From: [Holly Myers](#)
To: [Dusty Pilkington](#)
Cc: [Fiske Firebaugh](#); [Holly Duncan](#)
Subject: RE: BL-16-00009 Bailey
Date: Thursday, July 21, 2016 6:16:52 PM

BL-16-00009 Bailey

July 27, 2016

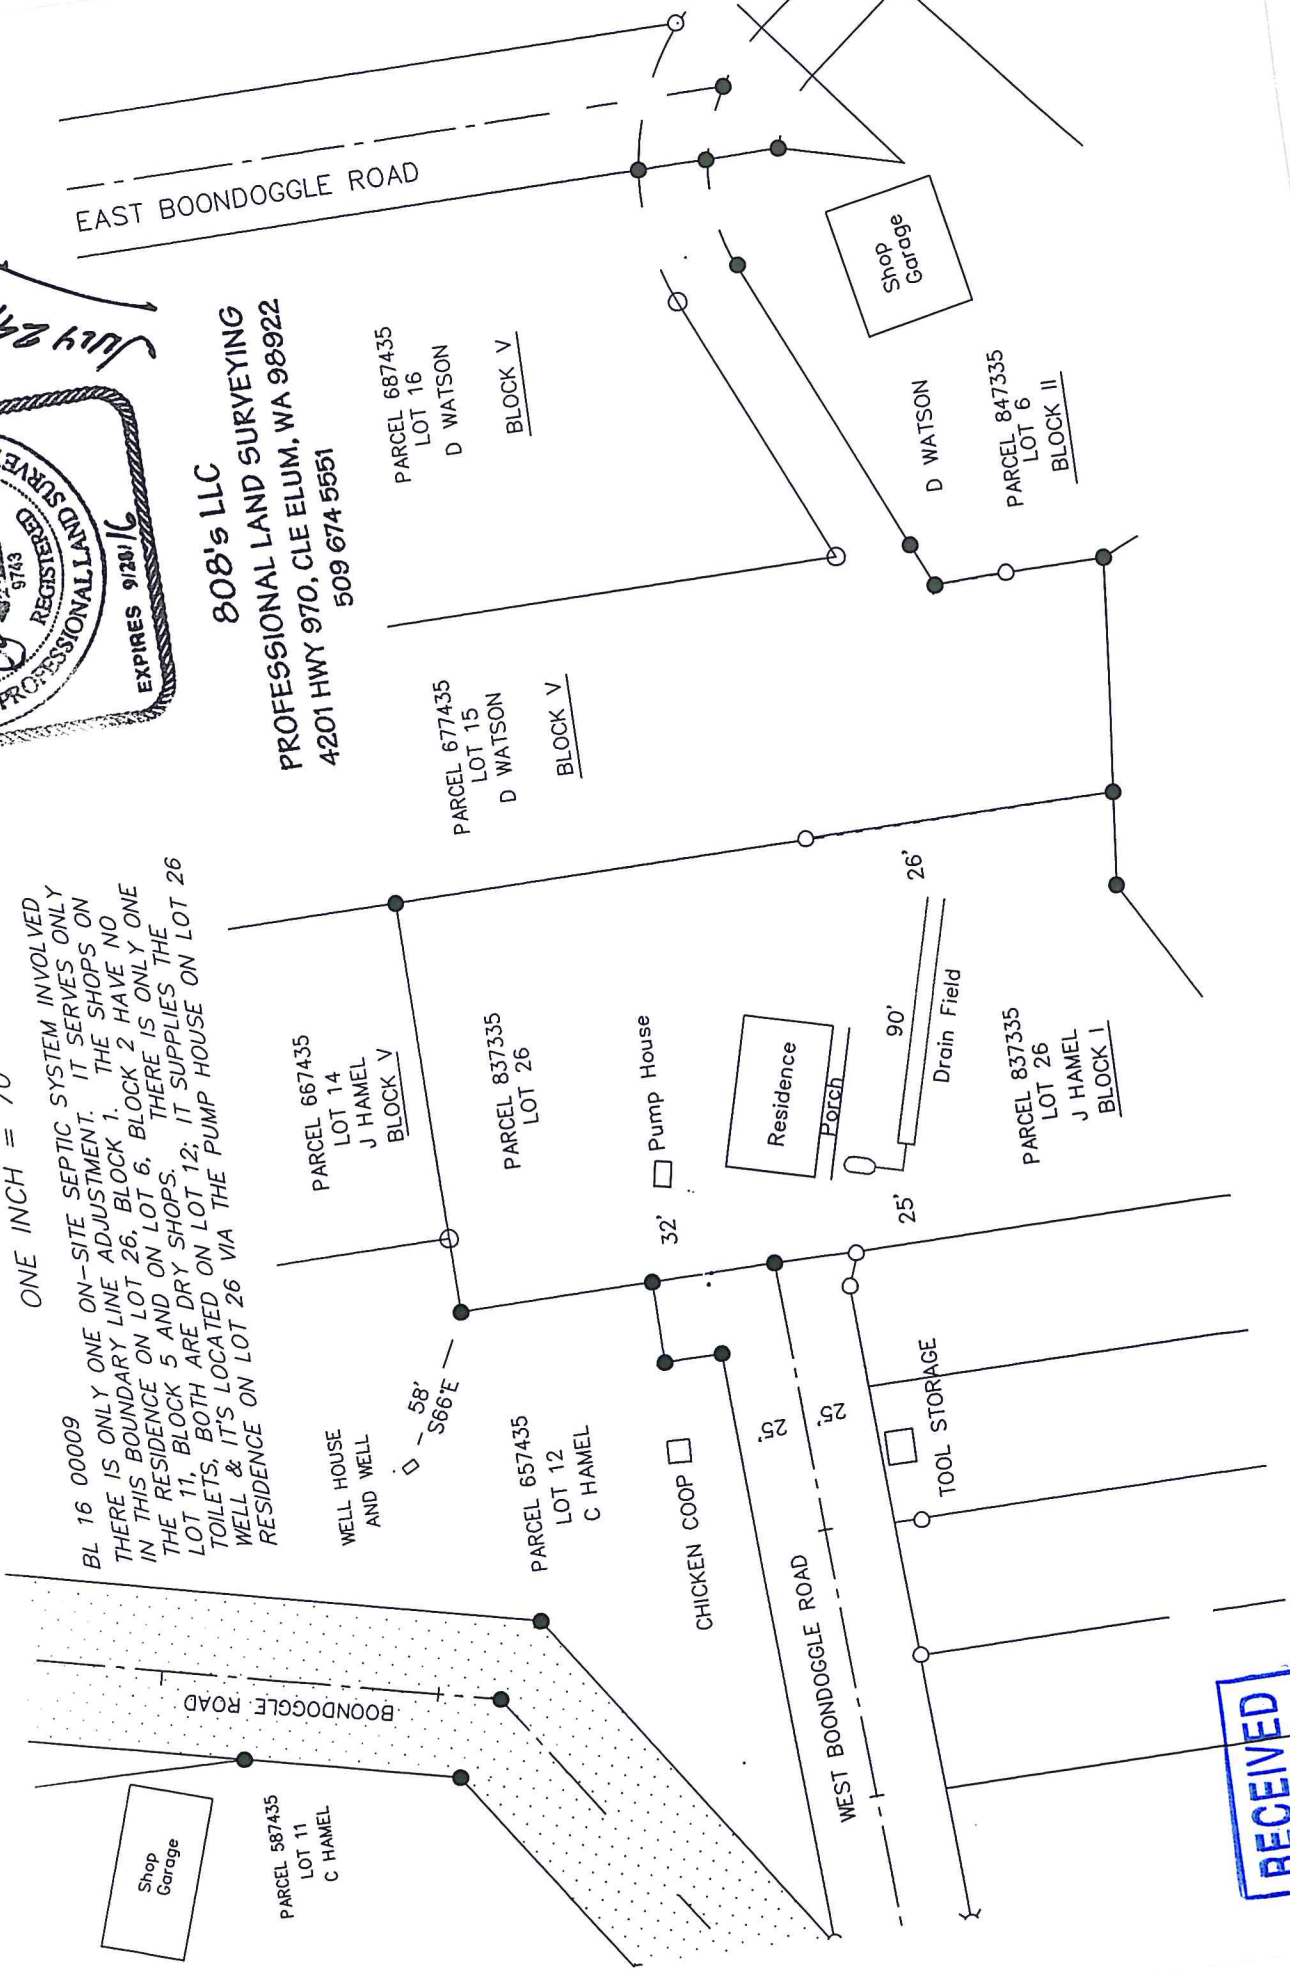
I am still looking at this site plan and not quite sure of the measurements. The applicant wrote in approximations. The new boundary lines are not clear compared to the existing lines in the site plan. Is the well within the pump house or alongside? Where? Distance from well to proposed boundary line isn't clear.

Please request that actual measurements are provided.
Sorry to sound like a broken record but it's common to provide the least amount of information and have to continue to request, review and re request.
Its best to review every site plan against the unified site plan as is referenced on their application prior to accepting the application. The text below is copied from your BL application.

If it doesn't have all of the measurements marked and meet the USP requirements, don't accept the application as complete.

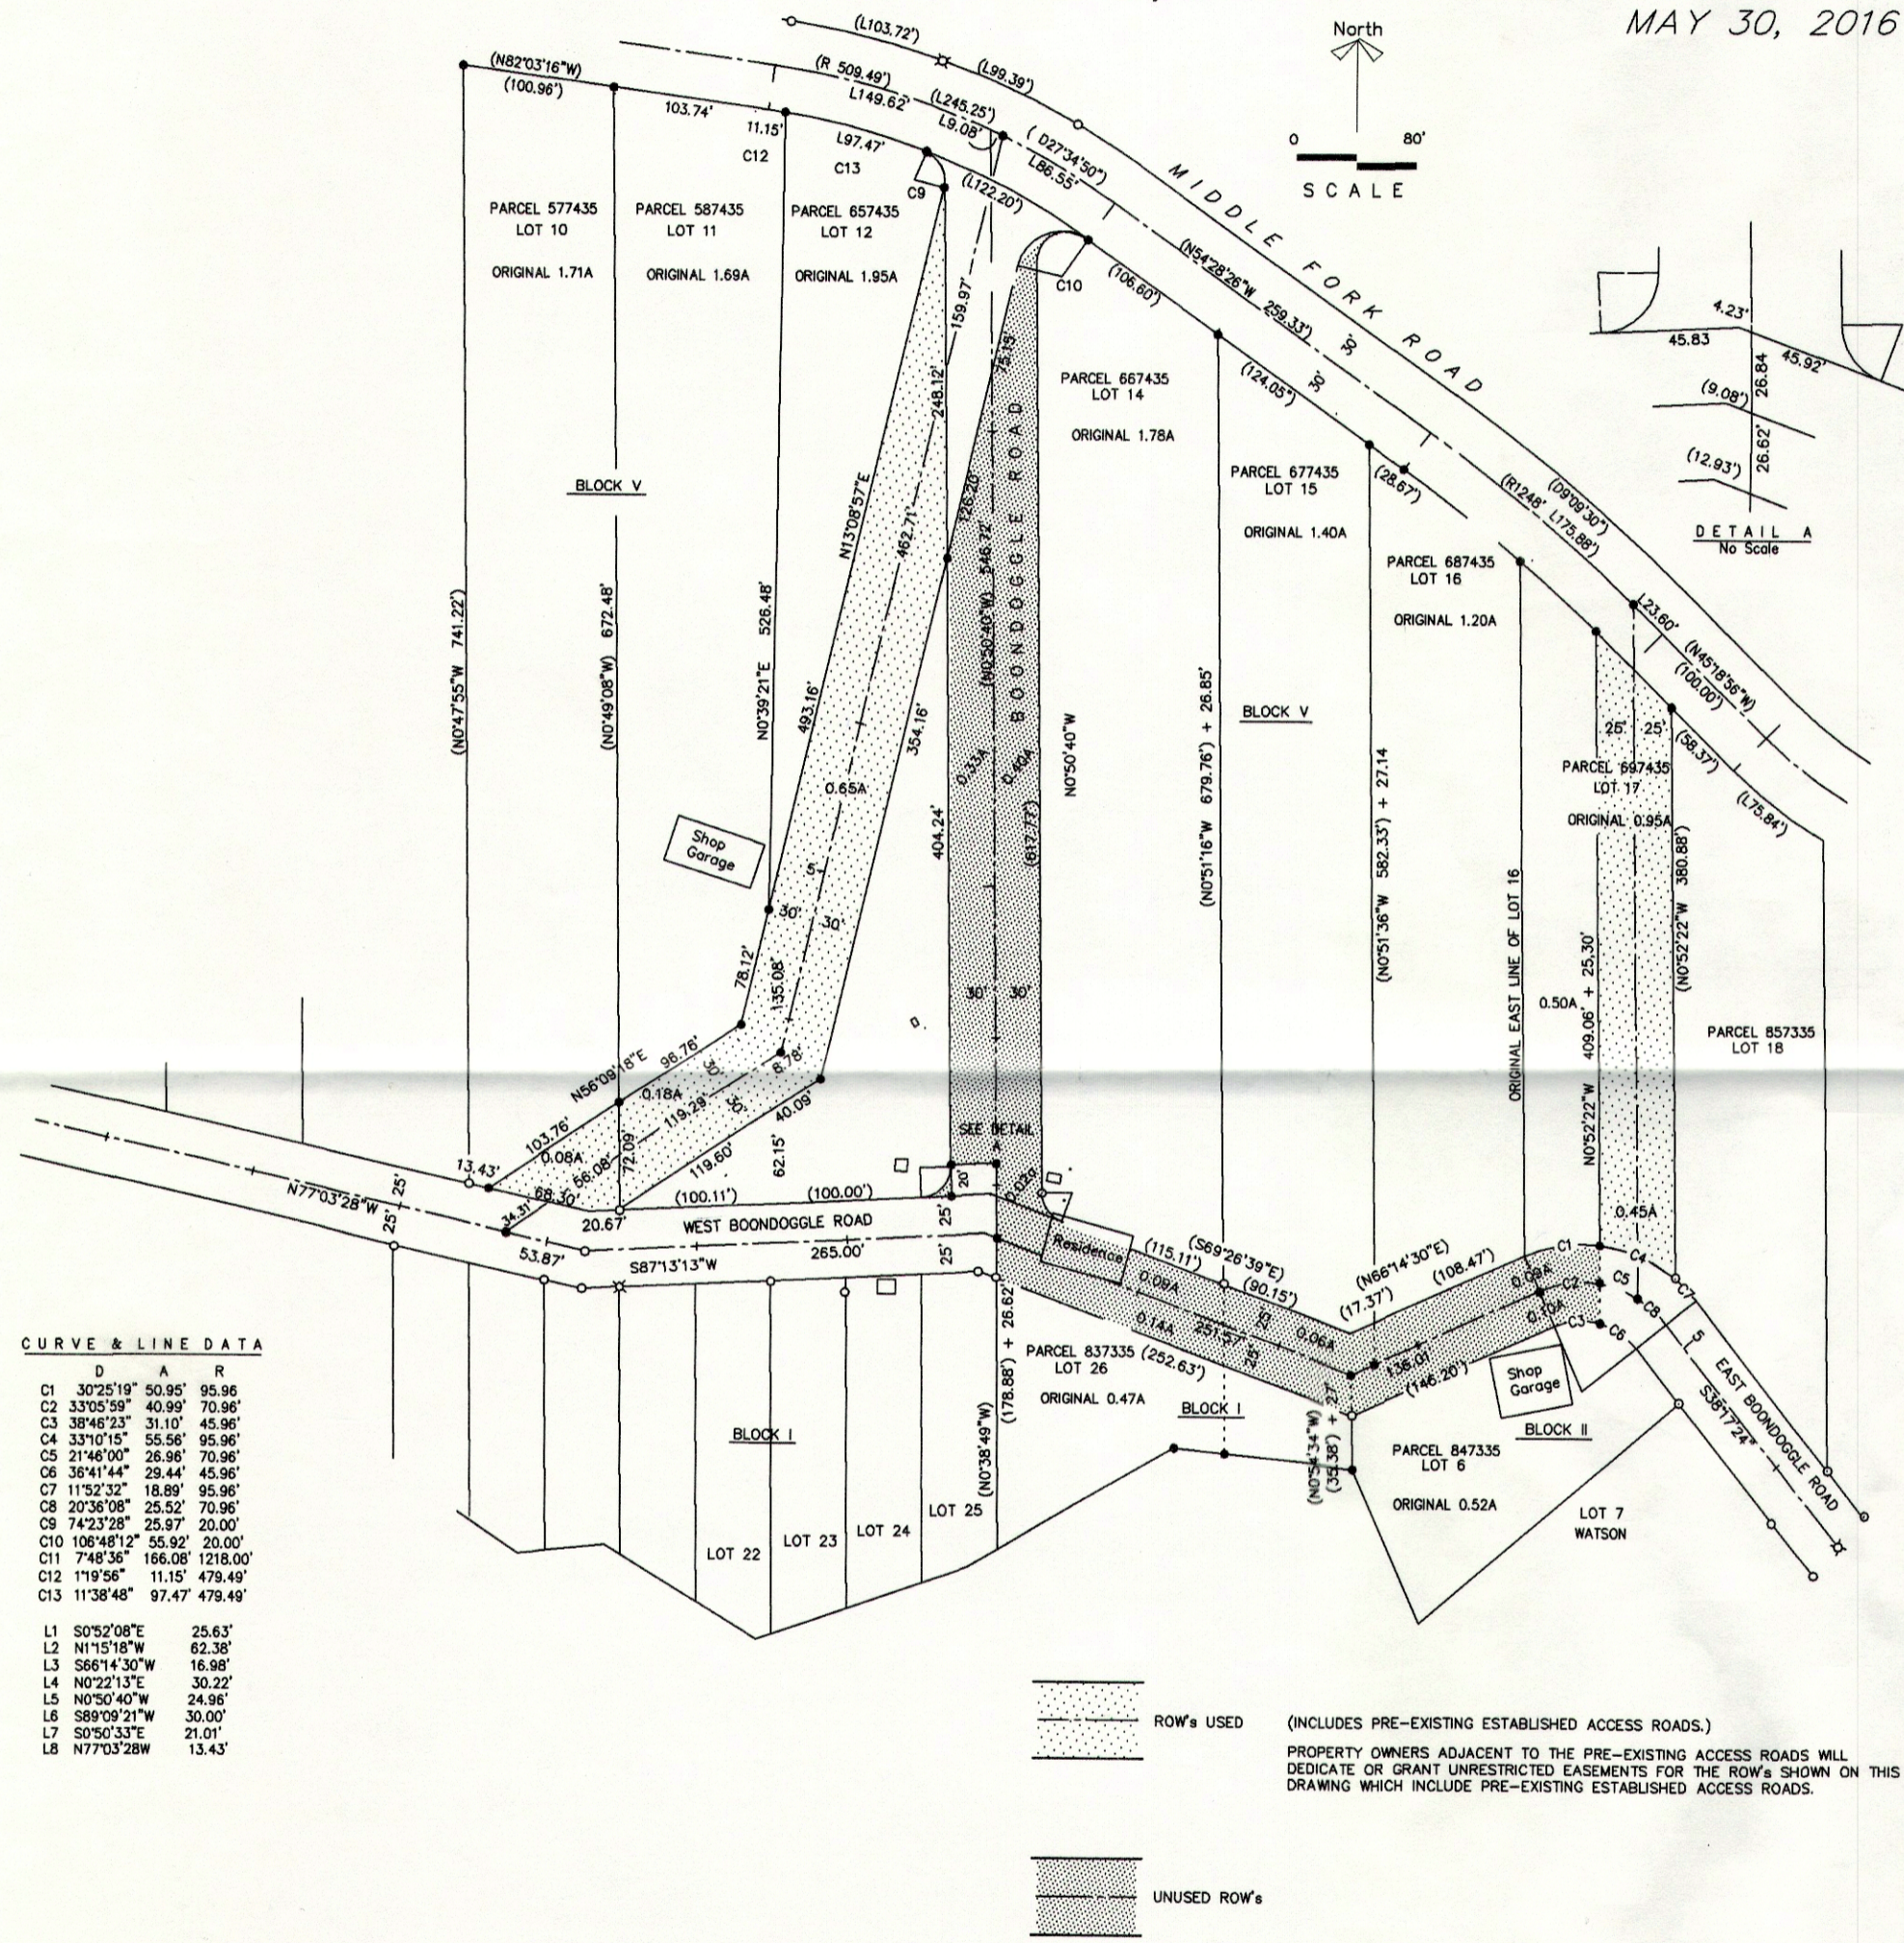
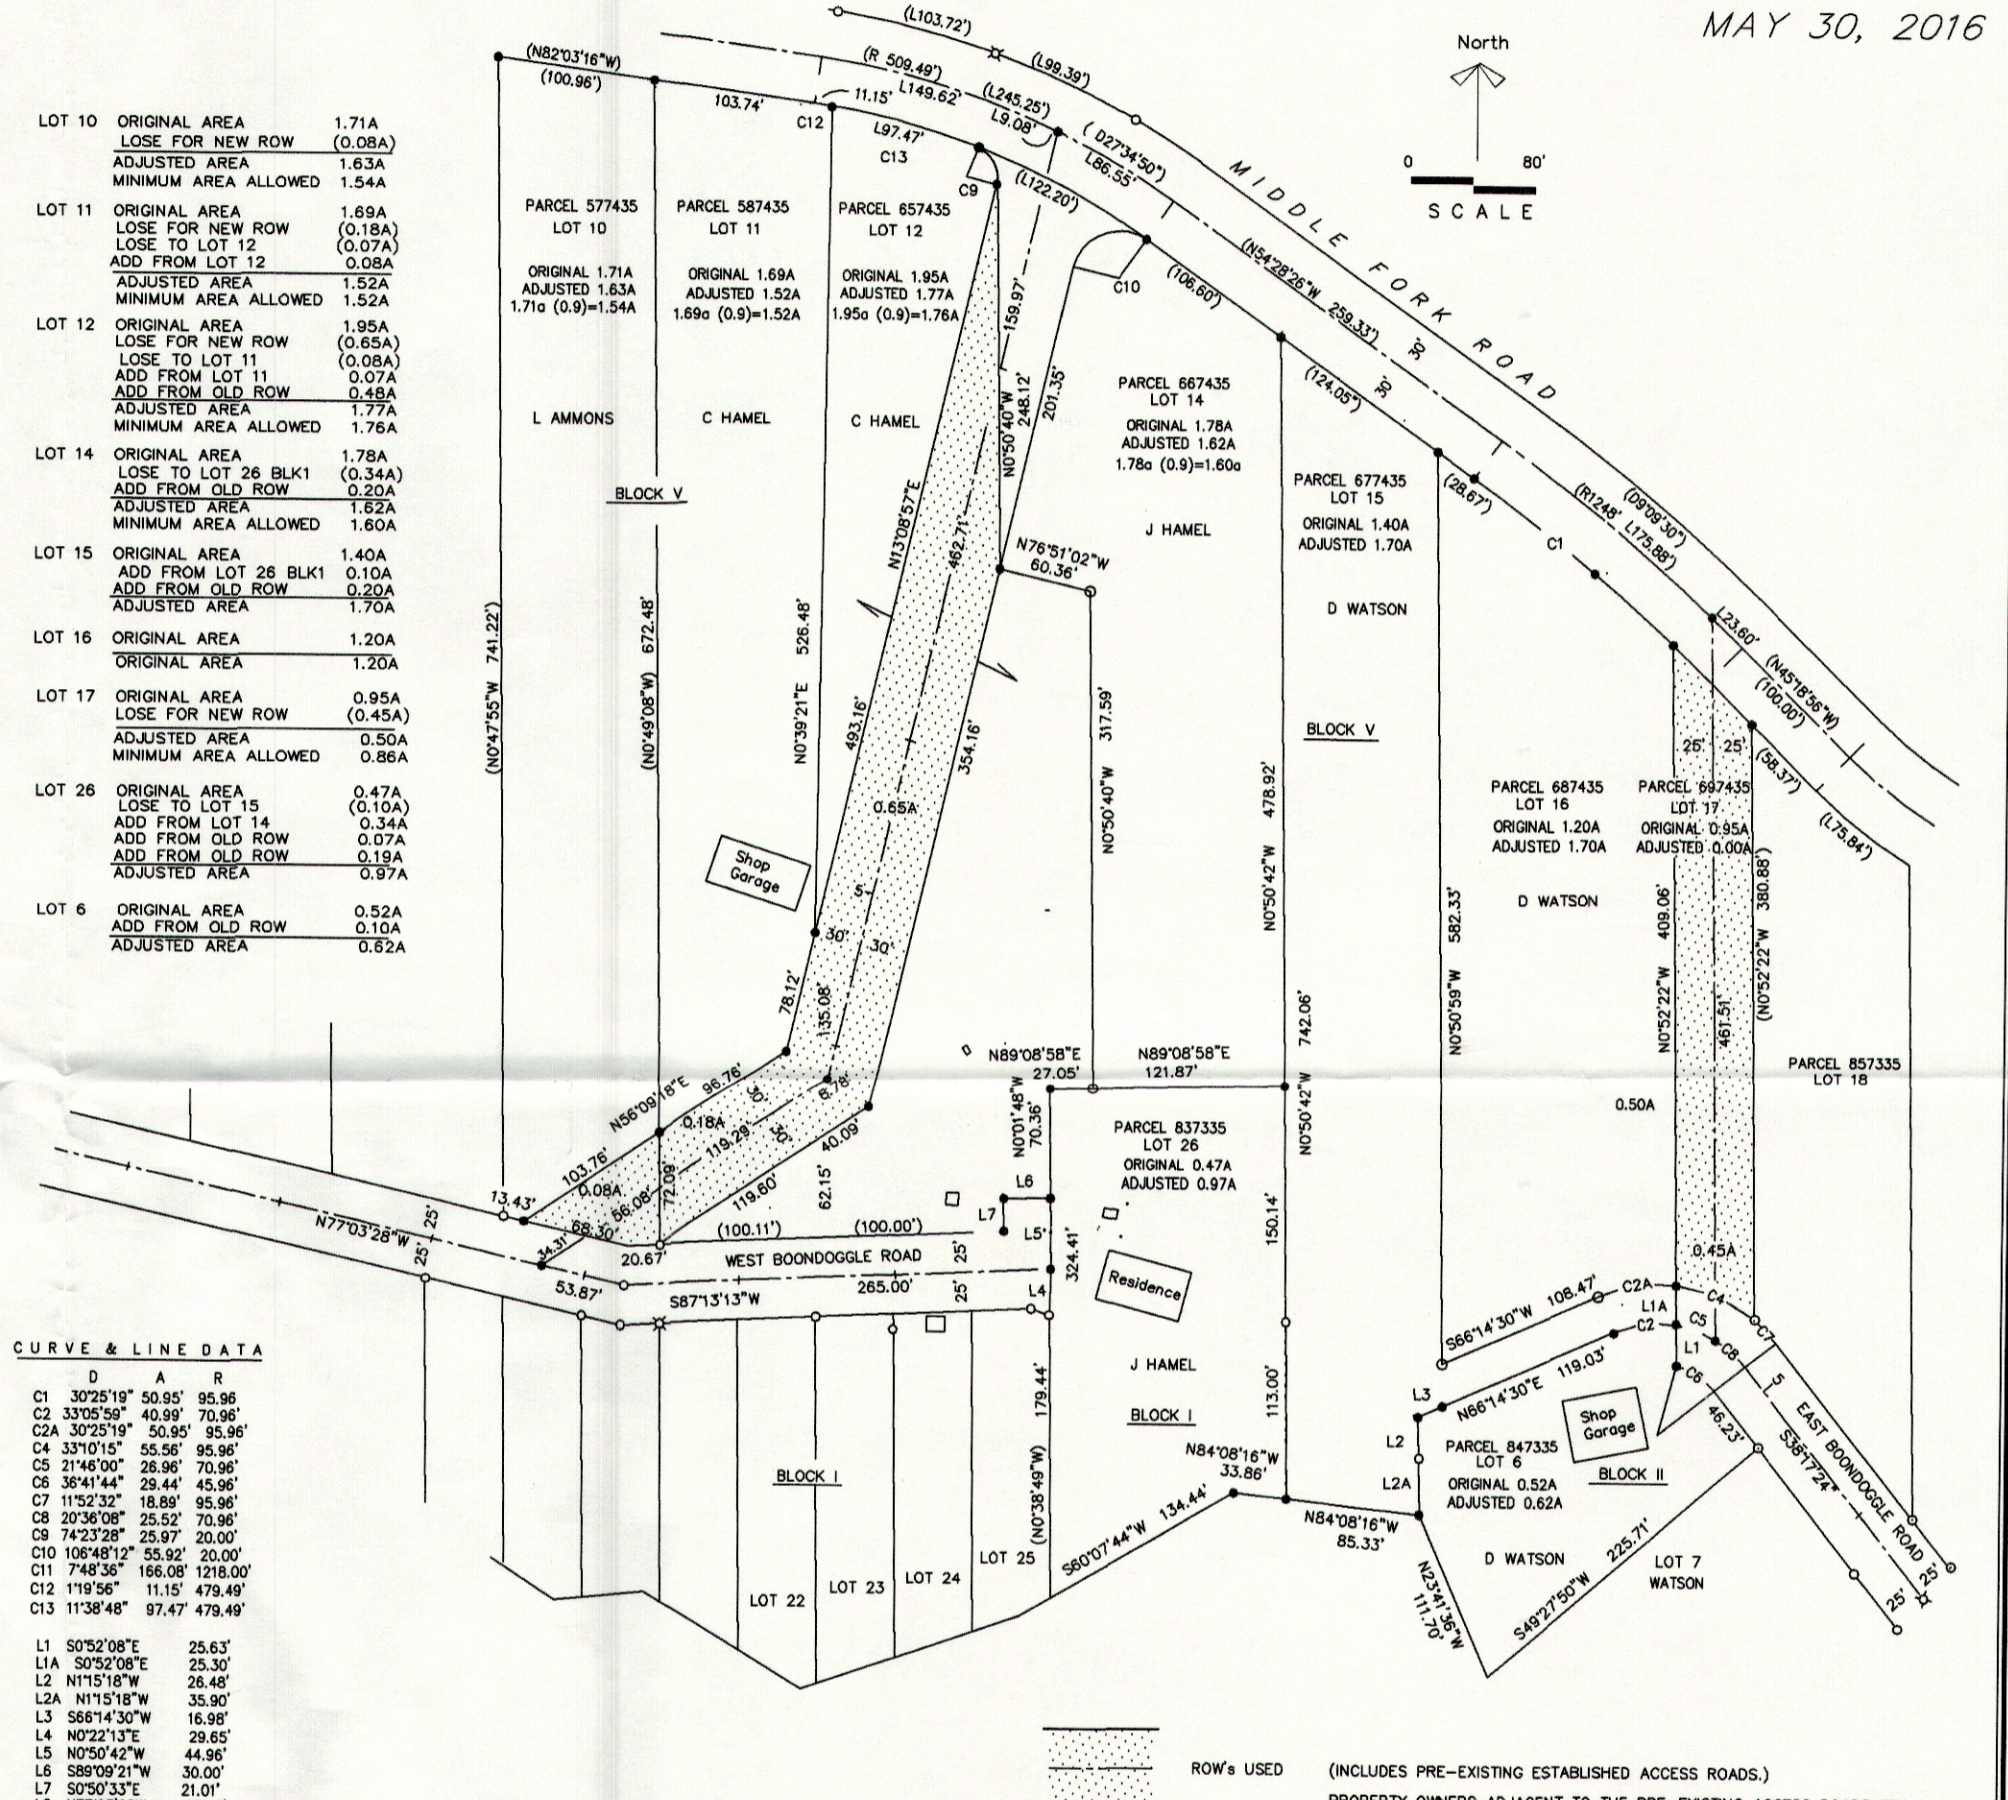
Please request applicant to provide distance from all septic and water source/equipment in order for us to provide accurate comments.

Locations of existing wells and OSS's needed. They are not shown.
